Project Name: MUNICIPAL ADDITION, UNIT 1

**CITY OF ALBUQUERQUE  
PLANNING DEPARTMENT  
July 25, 2007  
DRB Comments**

DEVELOPMENT REVIEW BOARD – SPEED MEMO

**PLAT OF TRACTS 2-D AND 2-E MUNICIPAL ADDITION No. 1**

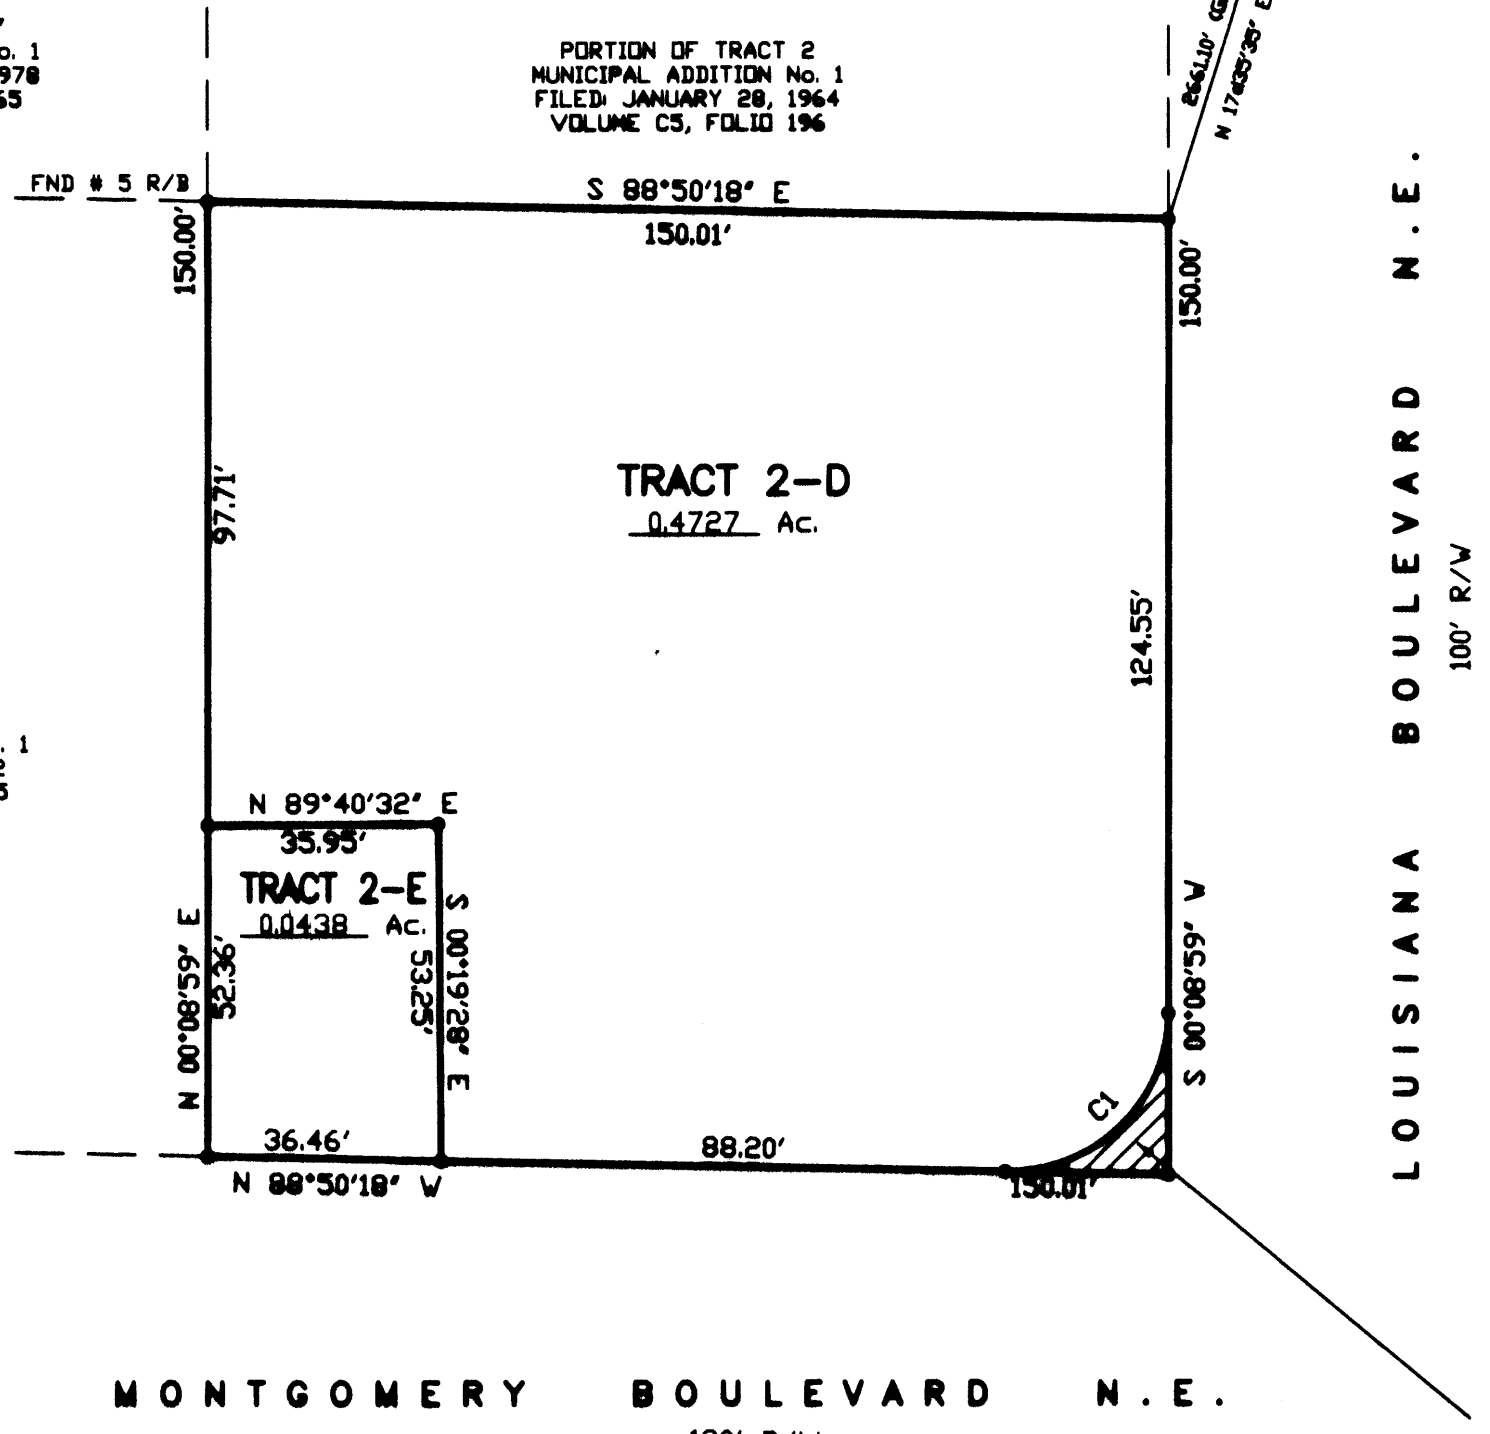
- CITY ENGINEER / AMAFCA: M + B note 10
- \_\_\_\_\_
- \_\_\_\_\_
- \_\_\_\_\_

A cross lot drainage easement is required.
